BR/239/14/A

To: Farhad Aarabi
Subject: RE: Further Information Required on Your Ref: PP-03642150 Our Ref: BR/239/14/A

Block Plan
Scale 1:500

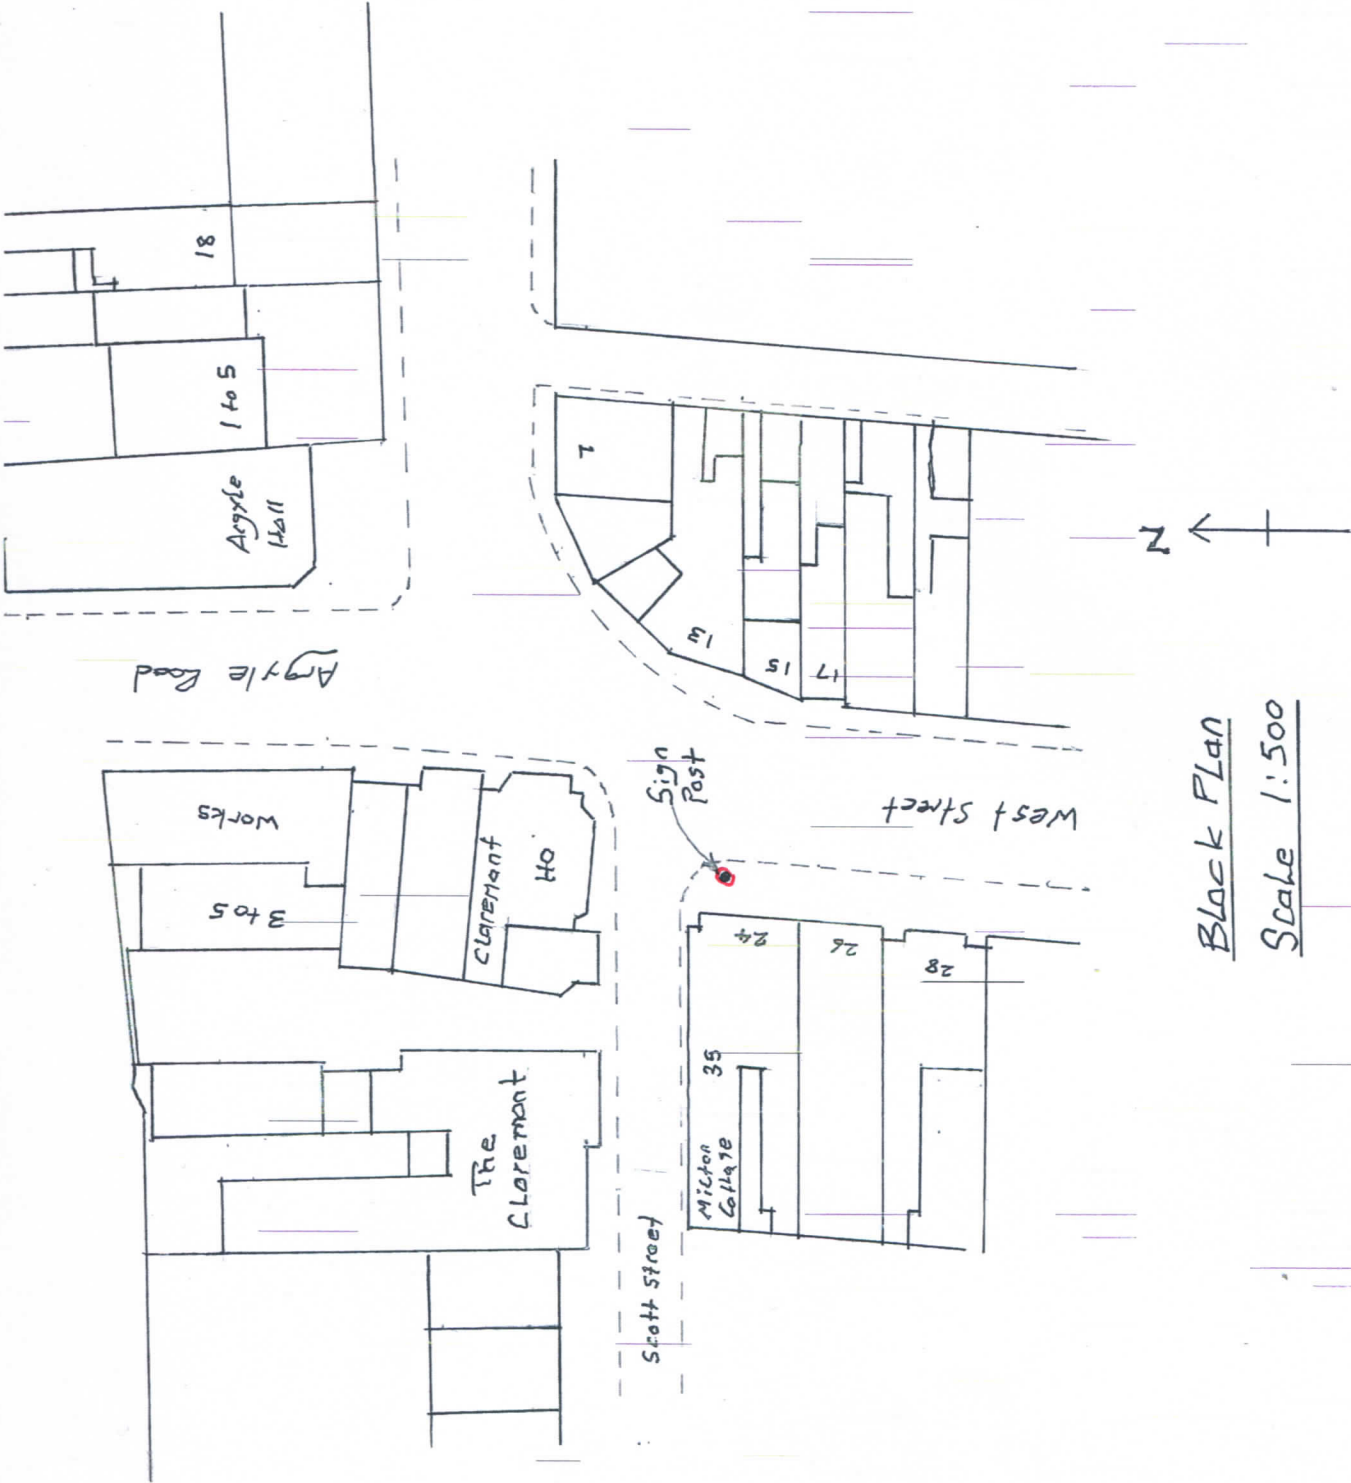
I have been on leave, returning this morning.
I have noticed that the block plan on the above application has The Claremont edged in red.
Please take the red edge off of just The Claremont and return to me by email.

I will need to change the site address to:

Land in front of 24 West Street.

On the block plan, can you please indicate the position of the sign post? Currently, the block plan is showing the sign post in front of 24 West Street and not the Claremont.

The position shown on the block plan is correct, my client thinks the public will notice the sign more if it is situated in West Street.
